Dear Sir

We note none of the matters raised in our submission in response to the previous meeting submission 7, were addressed by Highways England HE. We do hope you will consider this submission requires a response.

Of particular concern are those relating to the capacity at J10a and safety. We are at the final stages and yet still do not have absolute figures for maximum flows at J10a. This junction is designed to future proof the Ashford road network, allowing a huge raft of development to come forward, yet independent modelling shows developing only one site will 'stress' the junction, when all come on line will the junction fail?

Figure 2.1: M20 Junction 10a Scheme

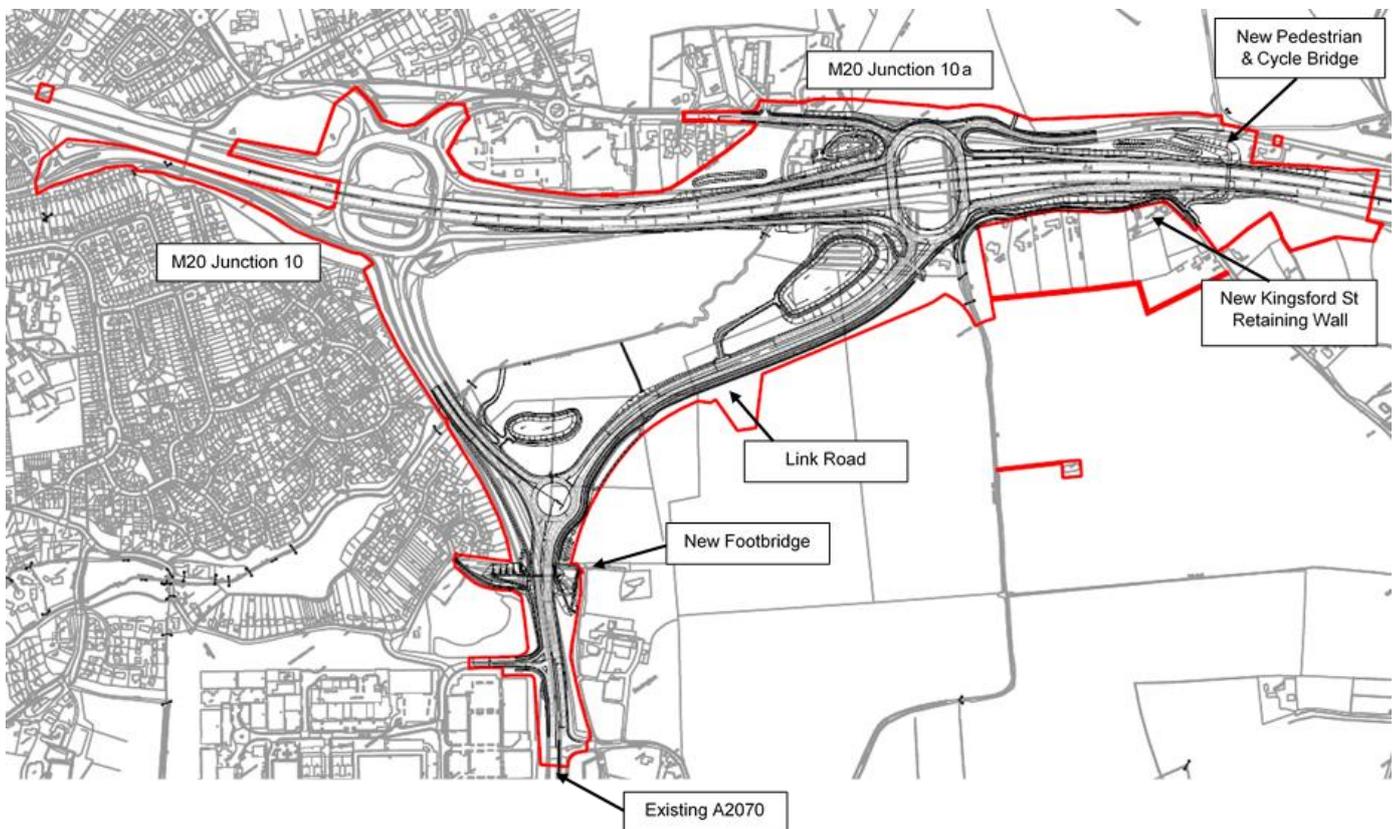
The applicant showed some measures of air quality. Using the aerial photo, drawing title "scheme outline –main and alternative scheme sheet 1 of 1"; to the west of J10 there is an area marked 'traffic signals upgrade', it is within the small development next to this area the air quality was measured.

As you can see this is nowhere near the new junction. It is expected air quality would actually improve at these sites as J10 traffic no longer has access the M20 at this point.

These measurements are not indicative of any impact of air quality on those near the new J10a.

Measurements should be taken at strategic points around the site, possibly the hospice, Kingsford Street, William Harvey Hospital and St Mary's grade 1 listed church. This could be used to prove the air quality models figures, that there will be no impact on air quality. It should be undertaken by Highways England rather than at a cost to Ashford residents.
